OXFORDSHIRE COUNTY COUNCIL'S RESPONSE TO CONSULTATION ON THE FOLLOWING DEVELOPMENT PROPOSAL

Application no: 22/03452/F

Proposal: Erection of new 128-bed residential care home (Use Class C2) together with associated access, parking and landscaping

Location: OS Parcel 6920 East Of Oxford Road And Adjoining And South Of Canal Lane, Bodicote

# Appendix 1

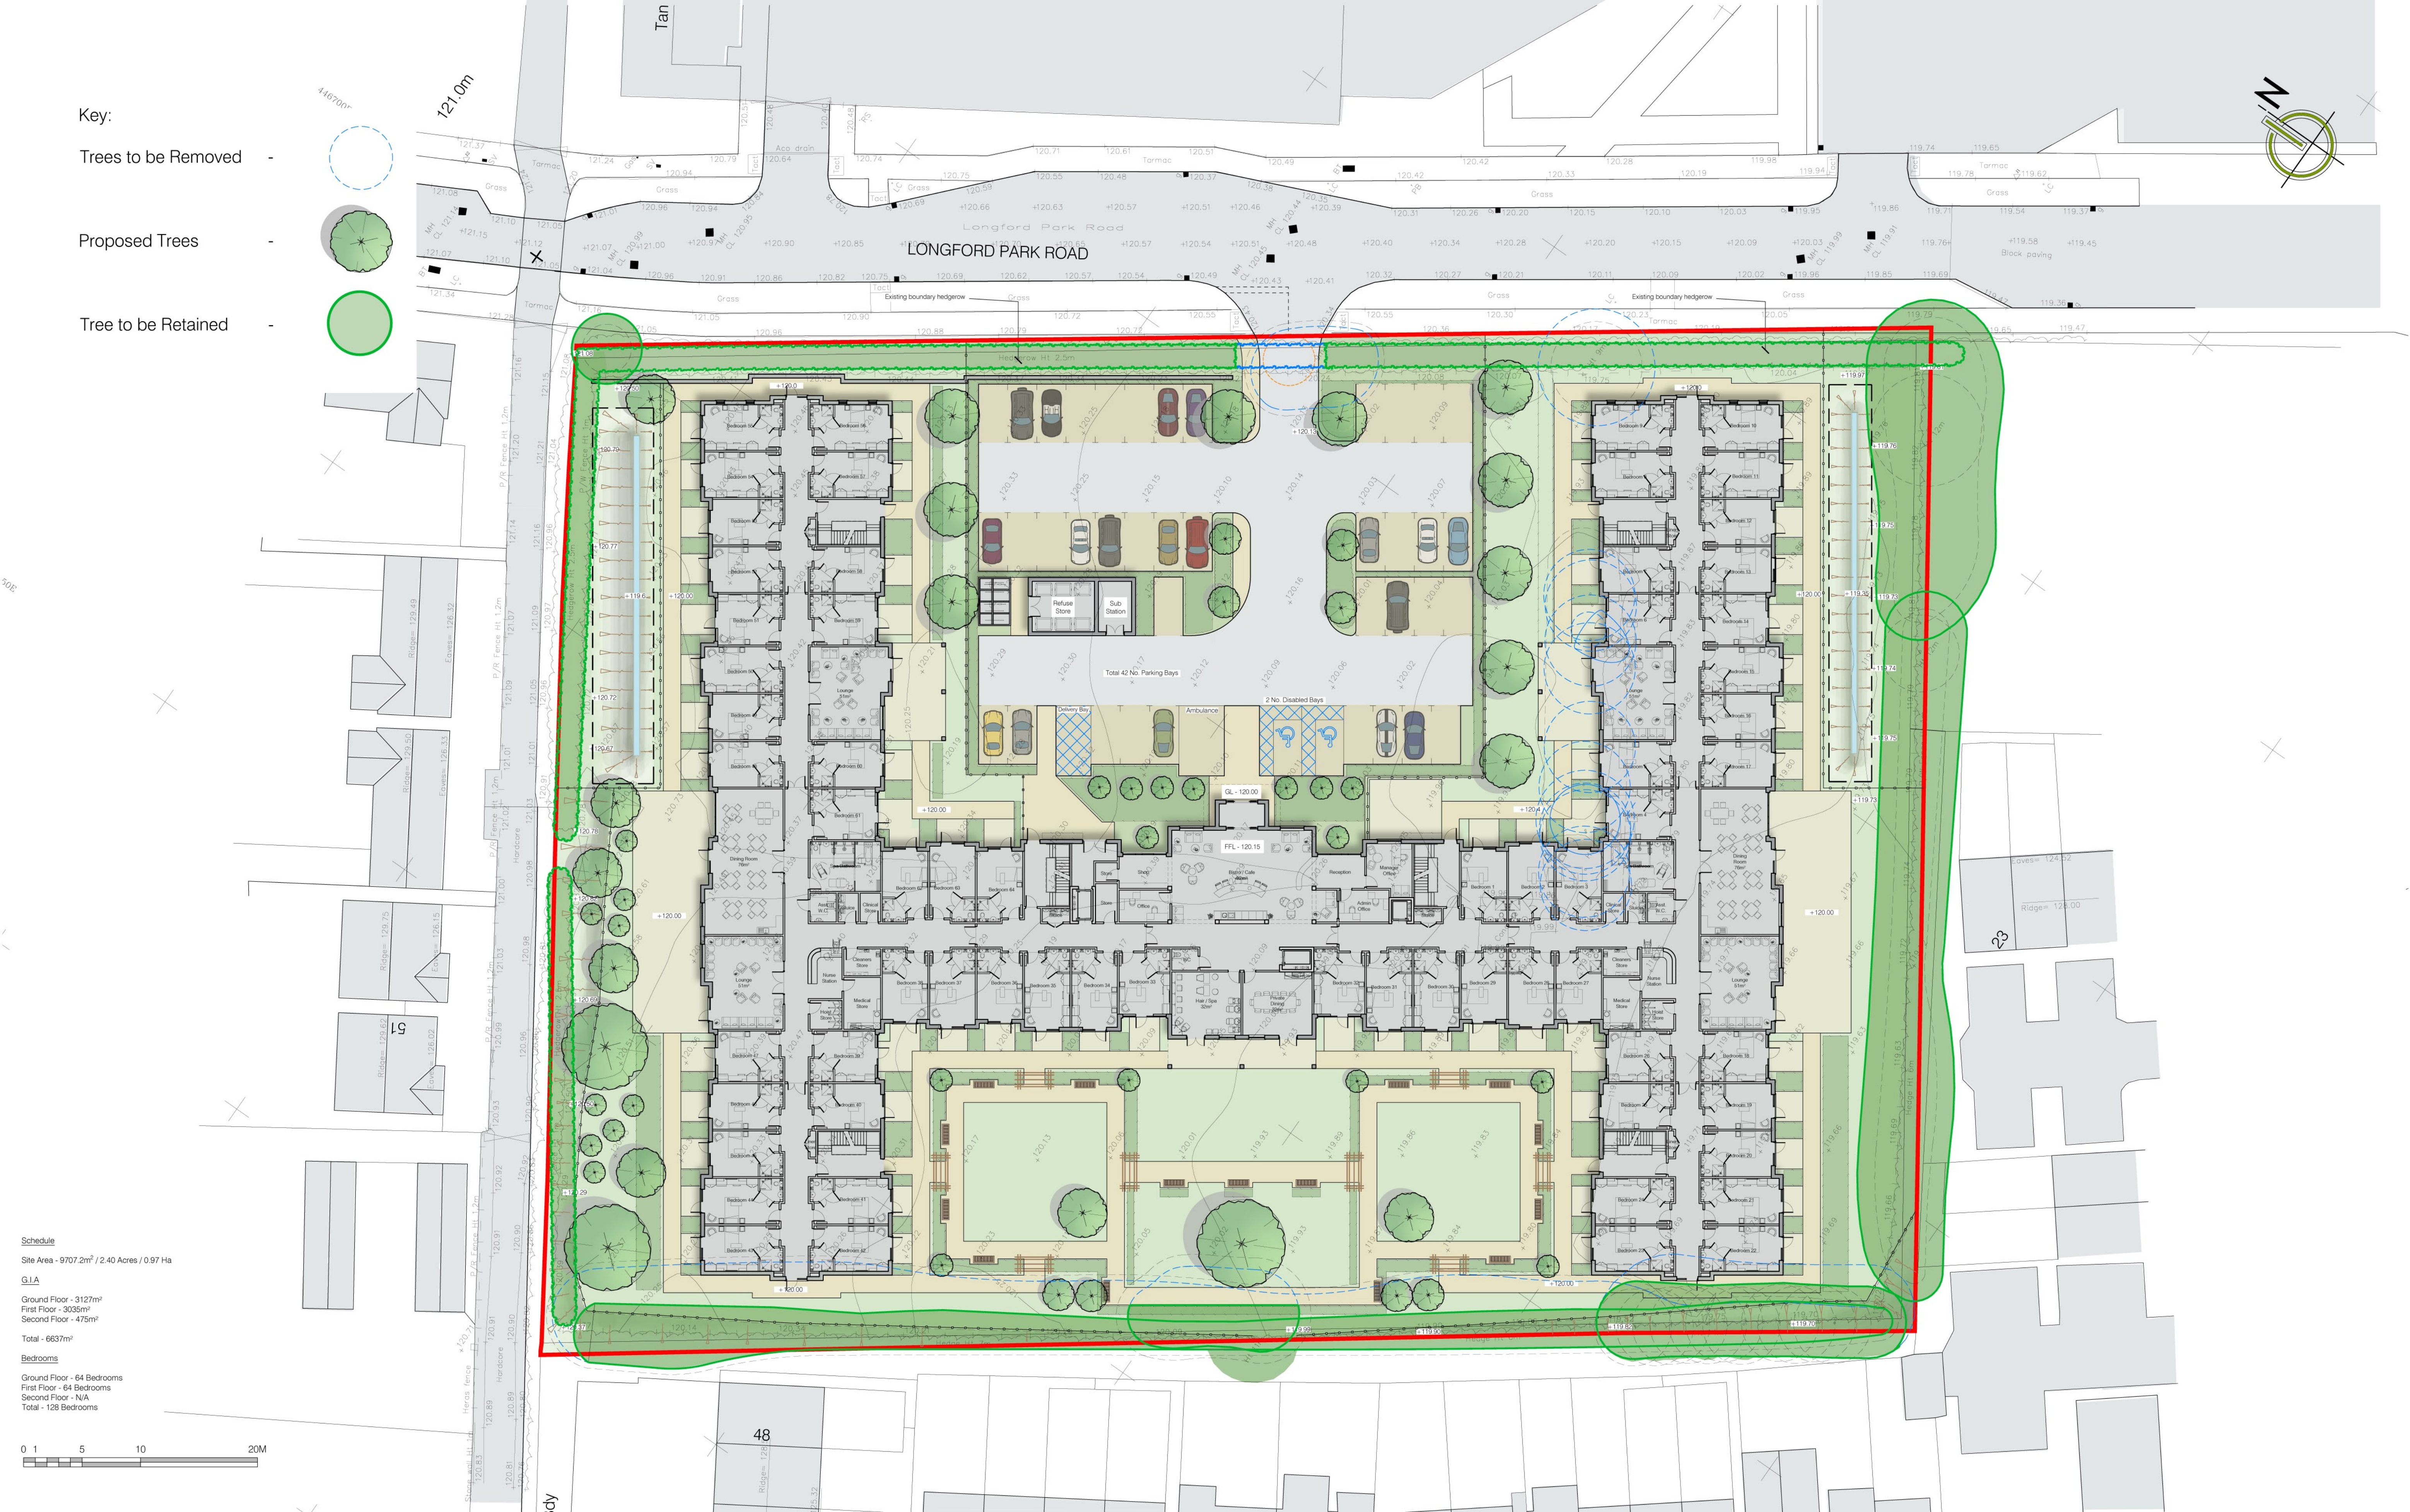
From the access junction, along the short access road, there is a footway on the northern side but nothing on the southern side. I consider that a section of footway is also required on the southern side of the access road in order to provide refuge for pedestrians leaving the site and looking to head south, who would otherwise likely be walking in the access road carriageway. This would reduce the potential for conflict between pedestrians leaving the site and vehicles turning in. I consider this particularly important given the increased likelihood of pedestrians using walking aides. **Objection**

Footpaths throughout the site appear to be disjointed and will mean pedestrians have to cross the car park. This could be problematic for those with additional needs. I would recommend that a continuous route from the main entrance should be considered.

The cycle parking is currently shown as being located directly adjacent to the bin store. This is not ideal for encouraging cycling, especially during the summer months. I would request therefore that the location of the cycle parking be reconsidered.

date <b>NOVEMBER 2022</b>	drawn by <b>T.A.S</b>	checked by <b>N.P.B</b>
scale <b>N.T.S</b>	status <b>PLANNING</b>	
drawing number <b>22071 - TR001</b>	rev. <b>A</b>

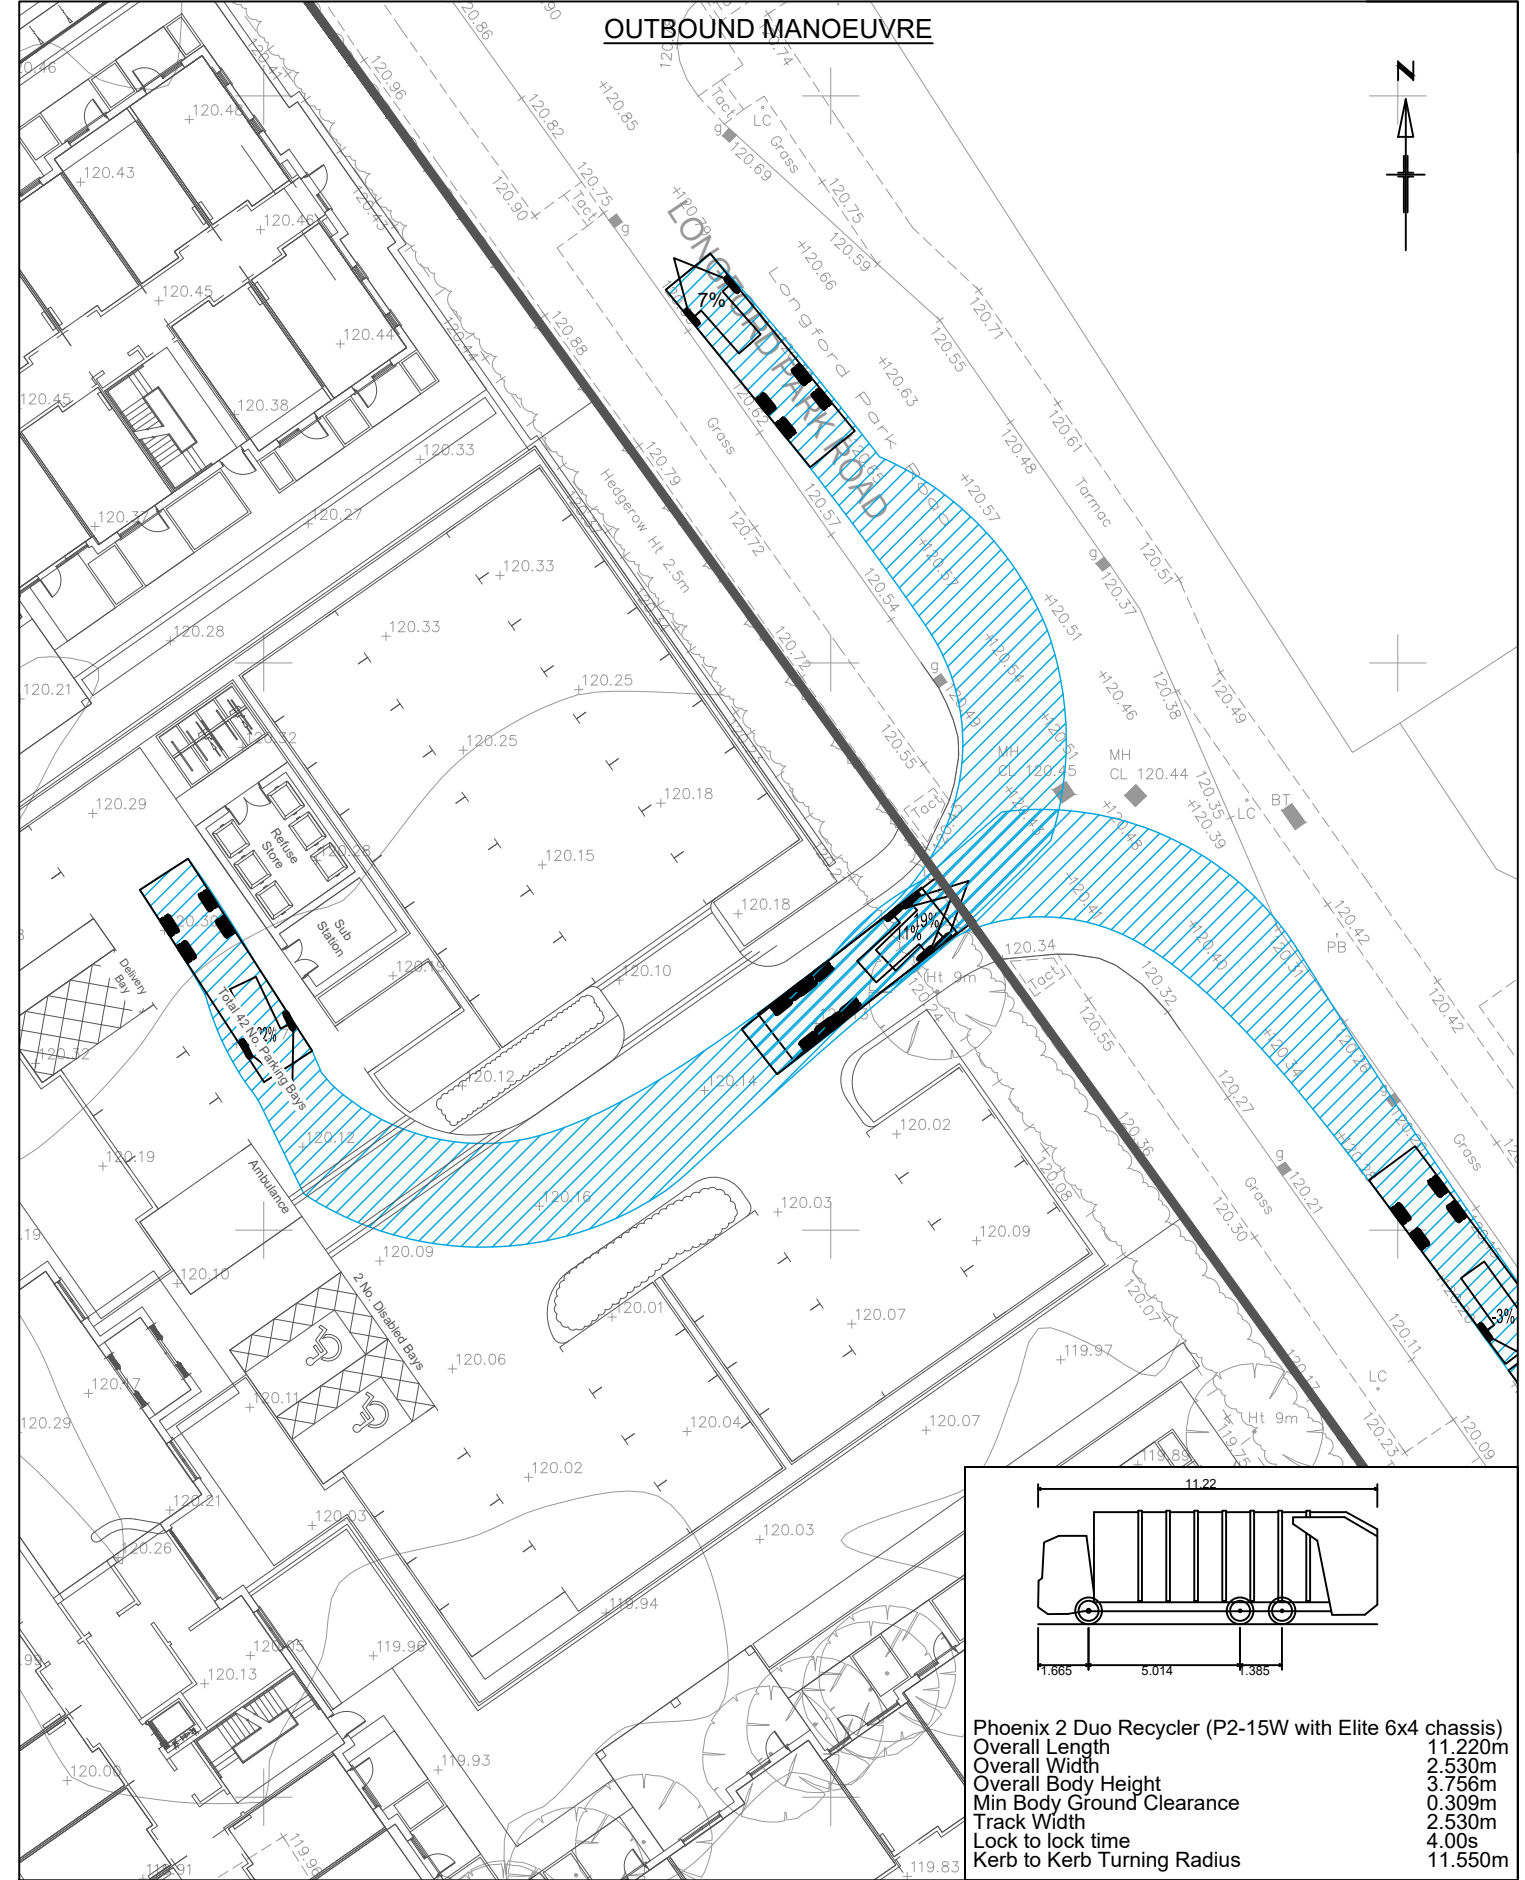
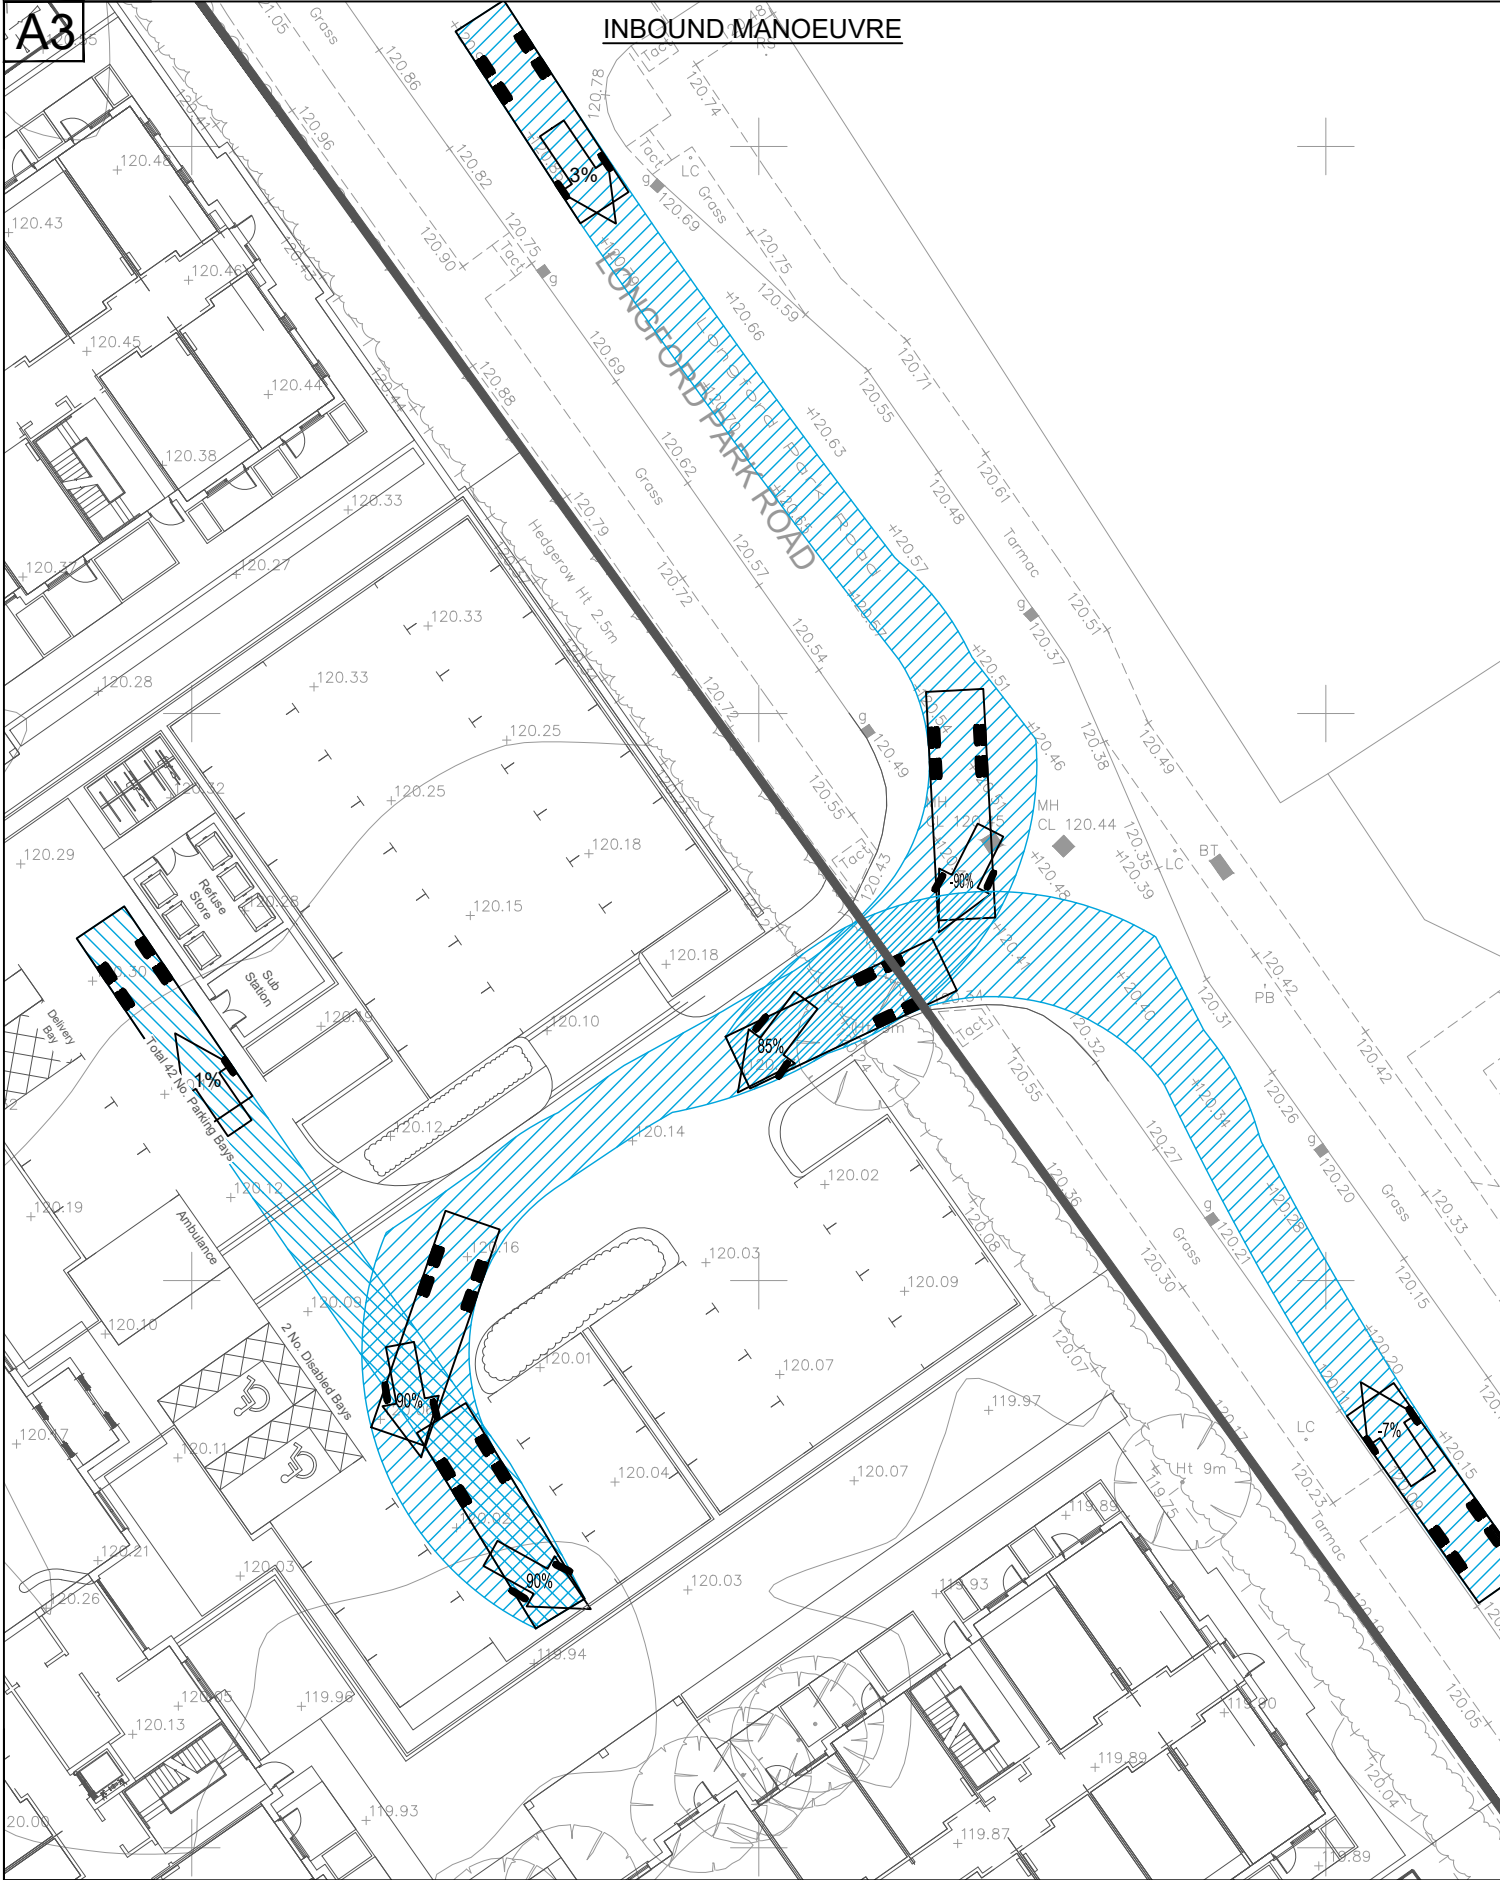
The location of the site access is acceptable, and I note that appropriate visibility onto Longford Park Road is achievable. Vehicle tracking has been supplied to demonstrate that large refuse vehicles can safely enter, turn and exit the site from the site access junction.
